Our Case Number: ACP-324410-26

Re: Proposed West Clare Railway Greenway Section 1: Kilrush to Kilkee Project
Kilrush to Kilkee via Moyasta, Co. Clare

Ref: ACP 324410-26 - West Clare Greenway – Kilrush to Kilkee

**ROUGHAN & O'DONOVAN**  
CONSULTING ENGINEERS

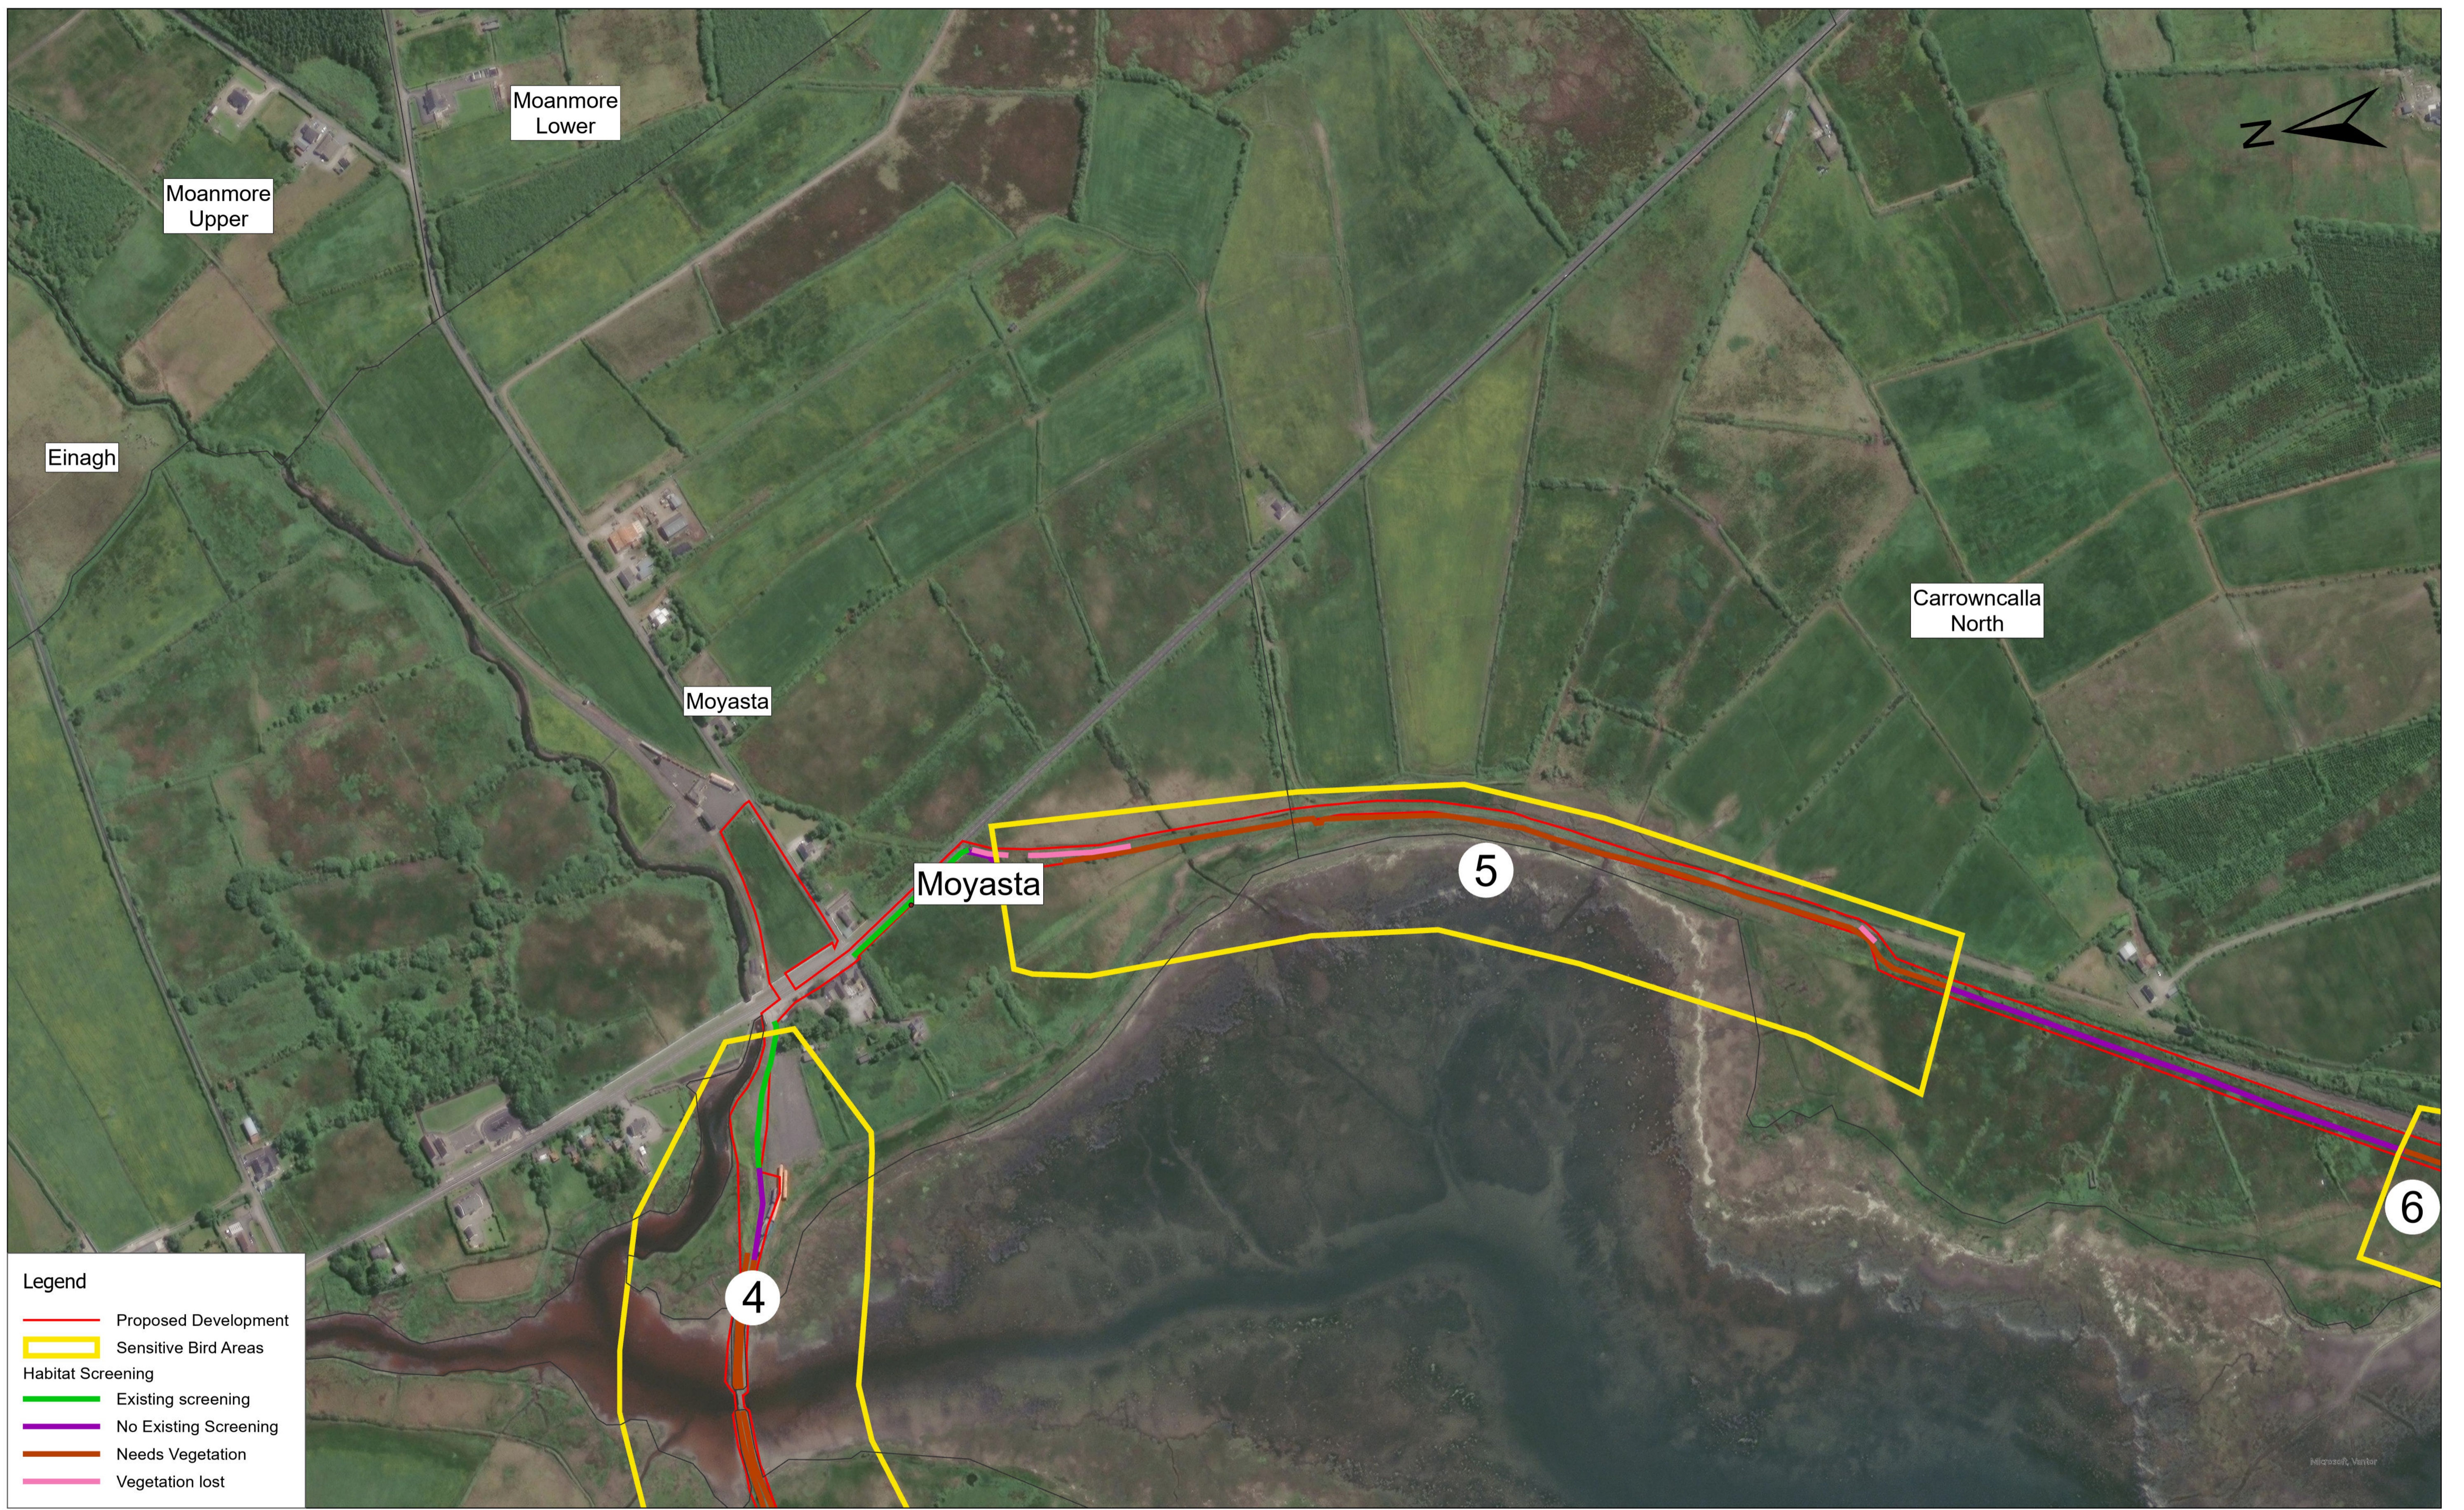
Sensitive Bird Areas (SBAs) are presented by the consultants following their survey work undertaken along with mitigation measures and conclusions. These SBAs are presented in a map extracted from the SBA Appendix, see figure 3 below. They are defined on page 29 of the Natura Impact Statement as “areas around Poulasherry Bay where the proposed development

is close to the coast and where there is no existing screening or, incomplete screening, and therefore could be impacted by the proposed development. Important areas for birds which are not close to the greenway are excluded.” Sensitivity is not defined by the number and distribution of the bird species within Poulmasherry bay itself but rather the level of exposure of the birds to disturbance. This needs to be considered more fully.

The presentations for each SBA includes the numbers of birds of different species recorded present at different distances out to 500m. BirdWatch Ireland staff reviewed the data provided and outline our response to below. In 8 of the 9 SBAs the majority of the individual birds recorded are of species that are of high or moderate sensitivity. In addition, for every SBA it is repeated that a “small” number of birds were found when this number actually varies from 12 to 585 birds. There’s no definition of small provided. Within 100m of the greenway the following is summarized from the data:

It is unquestionable that Poulasherry Bay and several key areas along the route of the proposed greenway are of very high importance for wintering waterbirds. It is not credible that it can be concluded that the addition of hedgerow planting as a screen could mitigate the visual and audible disturbance from people and dogs. Poulasherry Bay is noted as being a site where the birds are predominantly undisturbed and unhabituated to disturbance.

The mitigation for disturbance proposed is screening with planted materials in Sensitive Bird Areas and a 1.4m fence over Moyasta bridge. It is repeated through the Sensitive Bird Area document that there will be no change to the bird numbers in the area as a result of the screening. The NIS anticipates that adequate fast-growing plants and trees will be at stage of robustness to screen people and dogs and the noises they make to prevent disturbance within the 24-month period to build the greenway. It is difficult to imagine that this screening would prevent disturbance not to mind how many plants will fail to establish and the time it will take.
